Planning Application Ref: WA/68/21/PL

Location: Land adjacent to 1 Orchard Way, Fontwell, BN18 0SH

Description of works: Variation of condition 13 imposed under WA/18/19/PL relation to updated (July 2021) Arboricultural Impact Assessment

Drawing Title: Tree Protection Plan

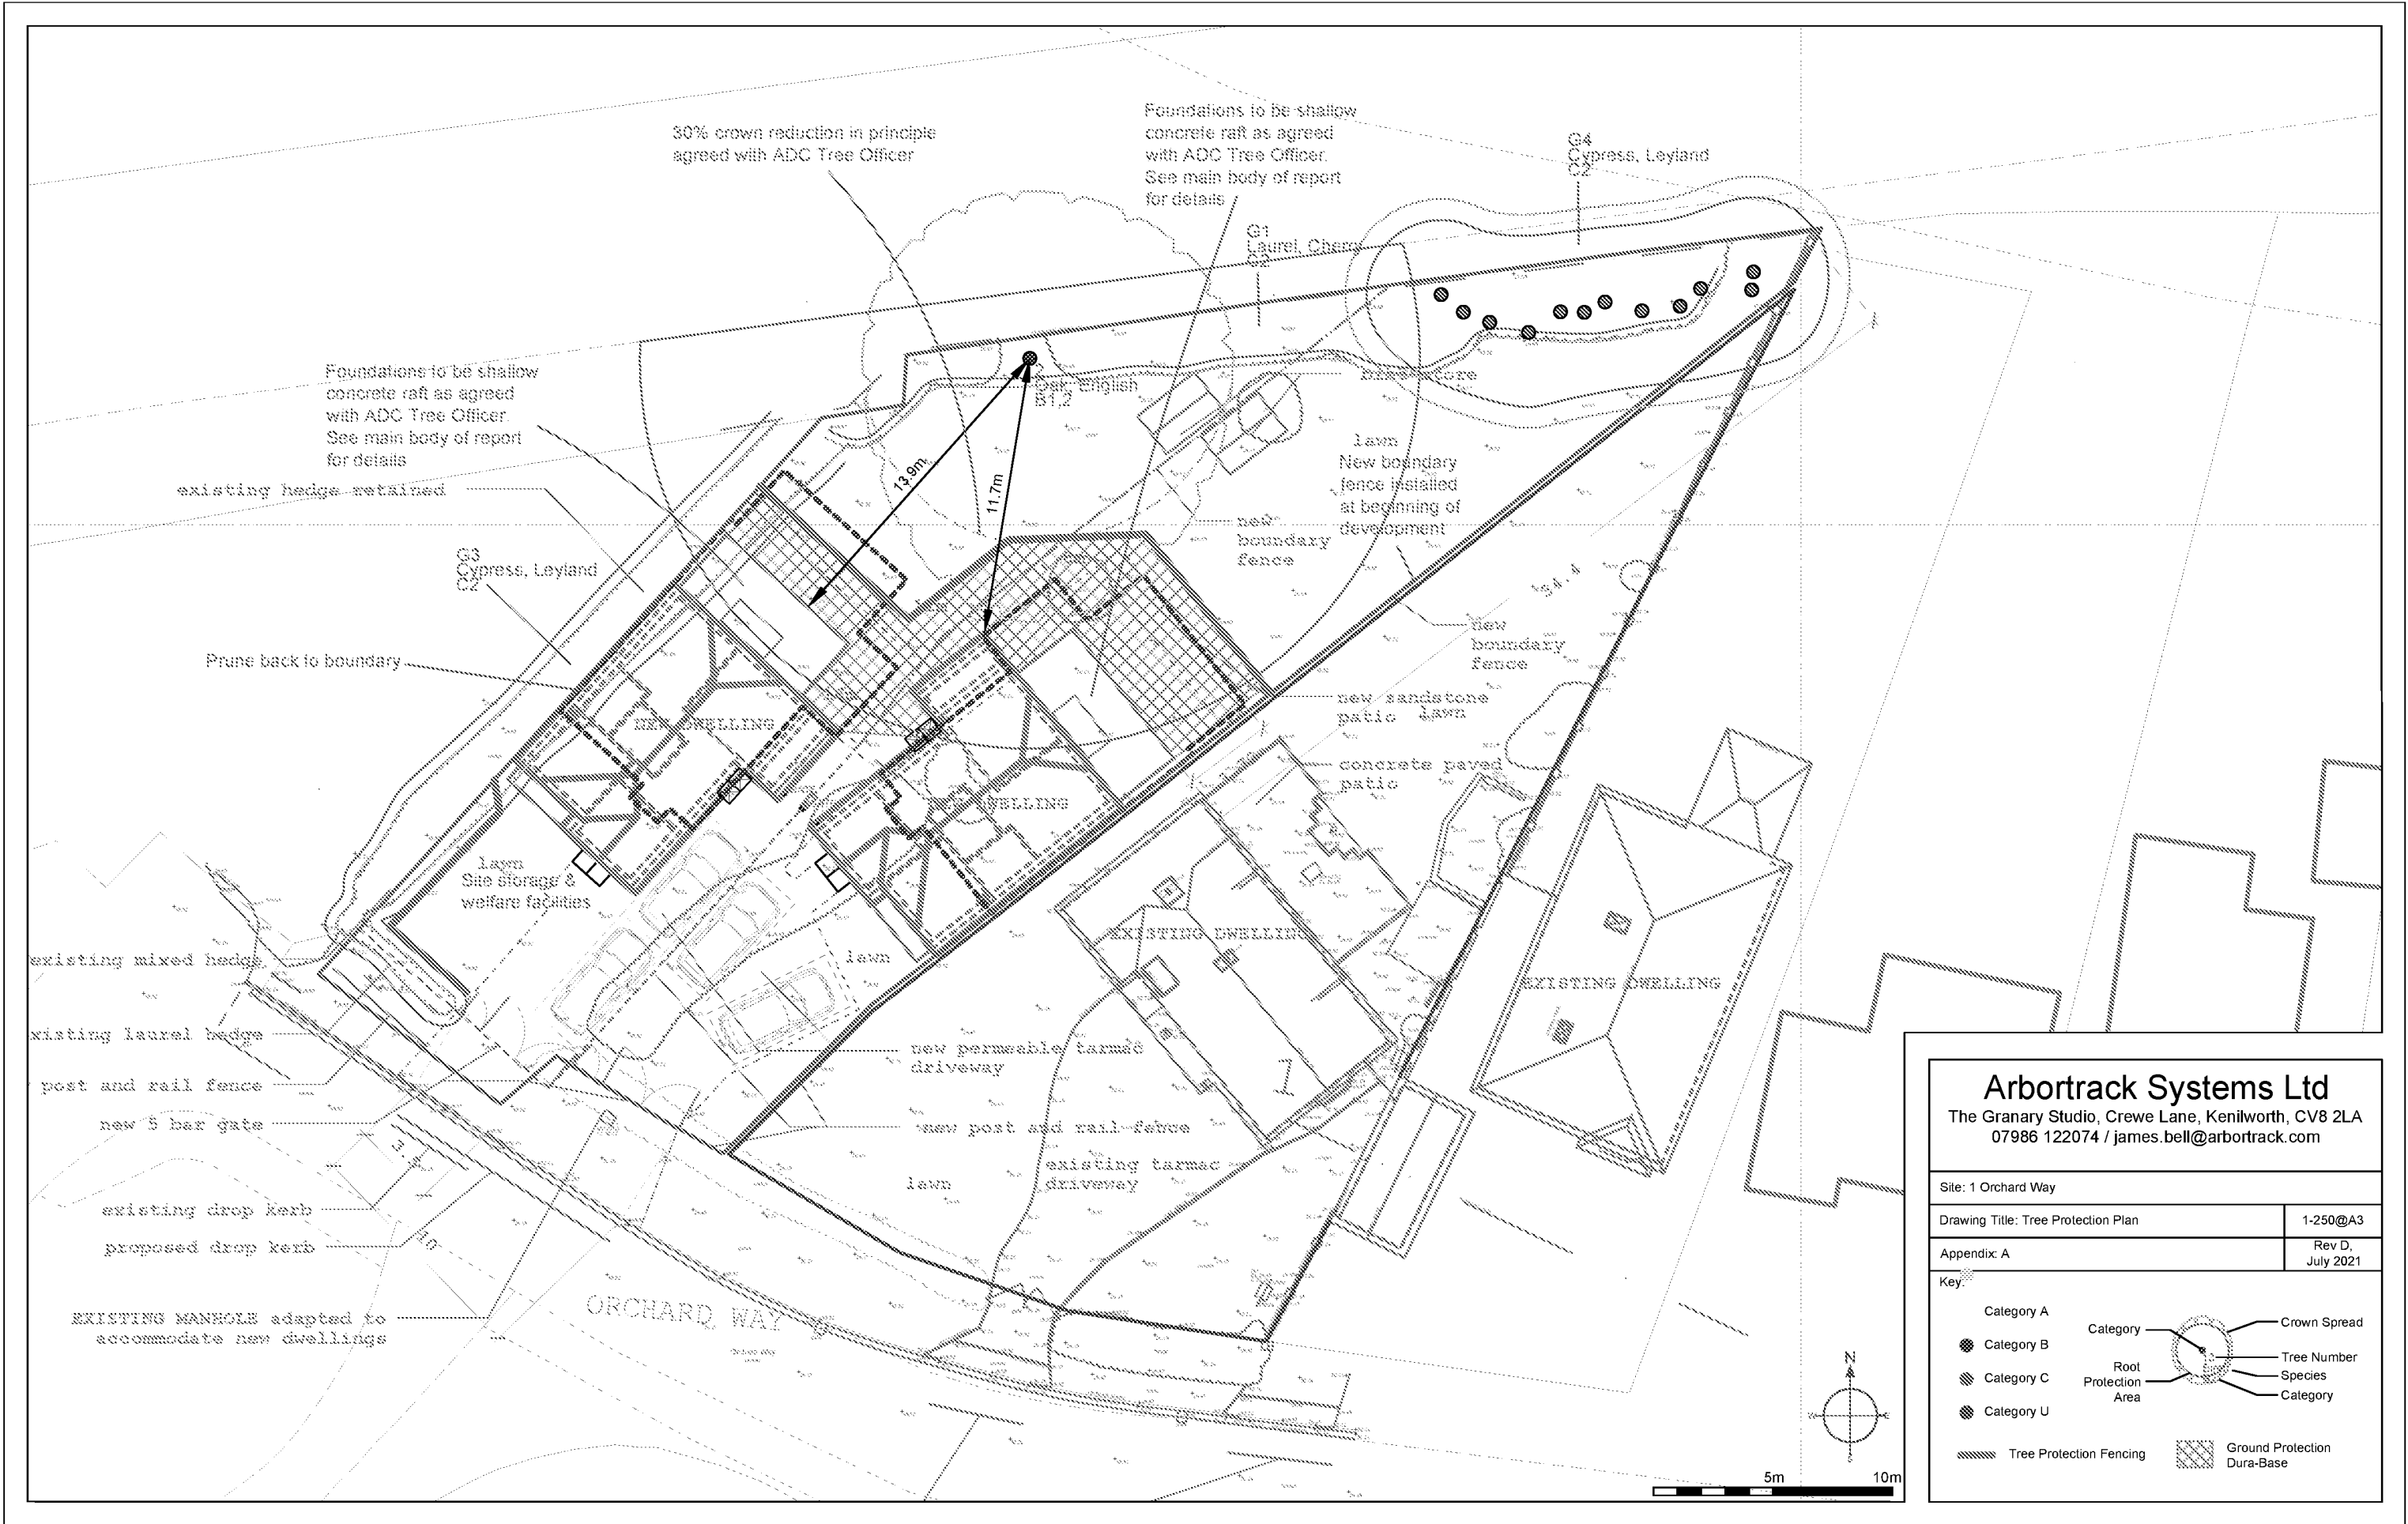
- I have undertaken a review of **Arboricultural Impact Assessment & Method Statement (Arbortrack Systems Ltd, ref: jwmb/ rpt1/ 1orchardway/ AIAAMS, 7th July 2021)** inclusive of Tree Protection Plan. Previous consideration from site provides further insight to the proposal.
- The Tree Survey data is comprehensive and accords with the requirements of BS5837:2012.
- The above report describes and illustrates refinement to the methodology required to satisfactorily implement the latest foundation proposal for both dwellings.

- Approved above-ground Tree Protection Measures have already been positioned and installed correctly. Ad-hoc inspections will be necessary to ensure ongoing compliance.
- While this scheme demands construction work within the nominal root protection area of a significant tree (oak – T2) adequate tree protection measures/construction methods are to be employed. It is achievable without undue detriment, providing there is adequate oversight and retained arboricultural input to ensure full and correct implementation of the same, as per the approved AIA & MS (see section 1.6 Site Monitoring).

- I recommend **APPROVAL** for this application, subject to the following condition being applied:
 - All activity at the site is to be carried out in strict accordance with: - **Arboricultural Impact Assessment & Method Statement (Arbortrack Systems Ltd, ref: jwmb/ rpt1/ 1orchardway/ AIAAMS, 7th July 2021)** and **Tree Protection Plan (Appendix A, Rev D, July 2021)**.
